re: **Geotechnical Response to City Review Comments**
Wateridge Residential Development
335 St. Laurent Boulevard - Ottawa

date: September 27, 2019

file: PG4064-MEMO.11

APPROVED
By Jamesdo at 9:46 am, Feb 11, 2020

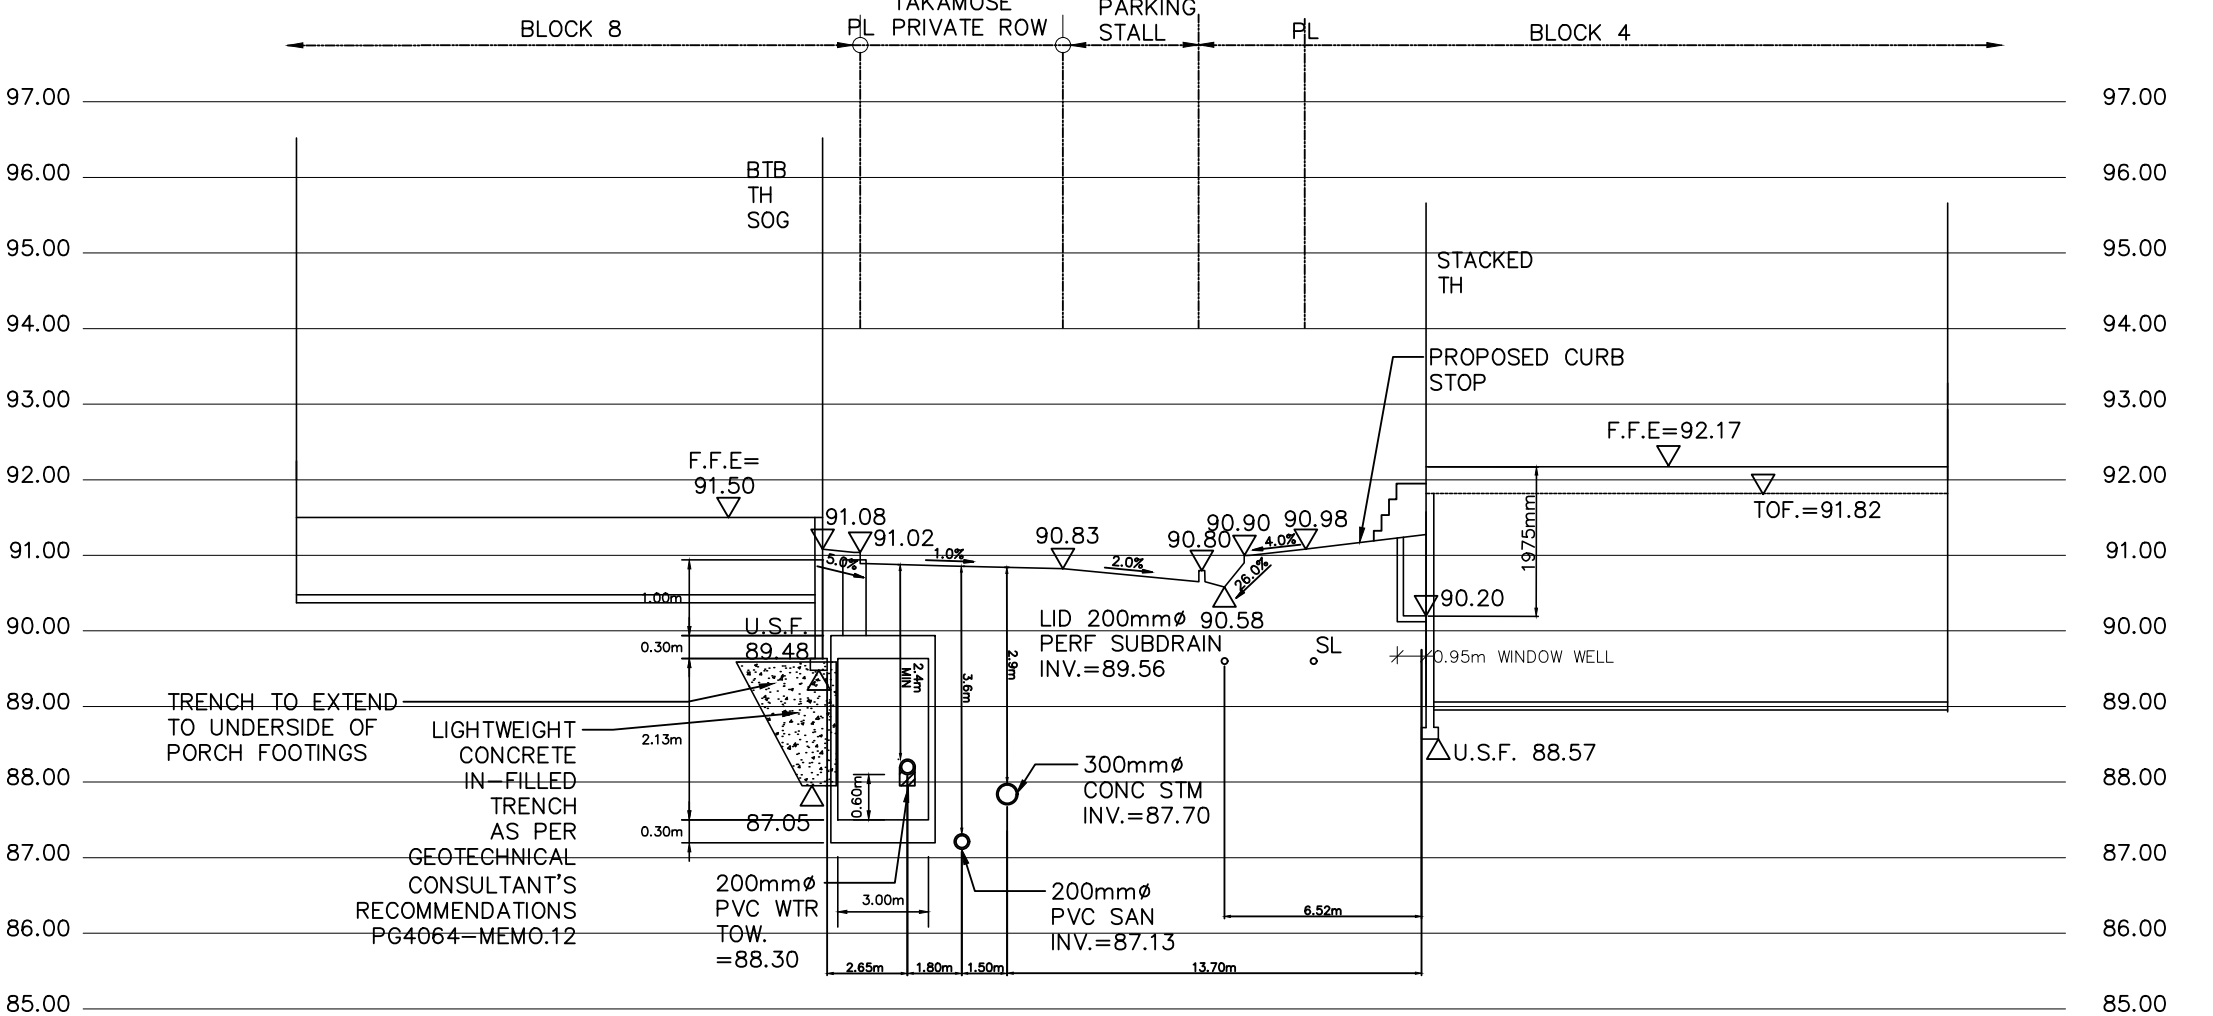
Comment: *The proposed private watermain and sanitary sewer along the north property line with a separation less than a horizontal separation distance of 2.5 m (edge of pipe to edge of pipe) is not supported. The reduced separation distance may be supported by Procedure F-6-1 however there appears to have been no consideration for future maintenance challenges as the sewer and watermain are located below the proposed underside of footings with minimal setback from the foundations. Repairing this private infrastructure without adversely impacting the structures and encroaching into the ROW will be difficult and unavoidable. Any maintenance costs will be significantly increased. Please investigate alternatives as any future repair costs will be the responsibility of the condominium corporation. Consideration shall be given to the future maintenance/repair challenges and associated costs with the servicing strategy and stormwater management solution proposals. Please demonstrate how this infrastructure would be serviced in the future for the City to review and provide recommendations from the geotechnical engineer. If these Blocks are to form part of the future condominium corporation the units shall be serviced internal to the development. Individual service connections under the current scenario to the public infrastructure within Mikinak Road would not be supported.*

Response: Reference should be made to PG4064-MEMO.12 - Lateral Support of Footings - September 26-2019 for information regarding the above noted comment. This memo should be read in conjunction with DSEL's drawings. This memo only addresses geotechnical aspects of footing/service lateral support. Impacts to ROW and additional costs to be addressed by Mattamy/DSEL.
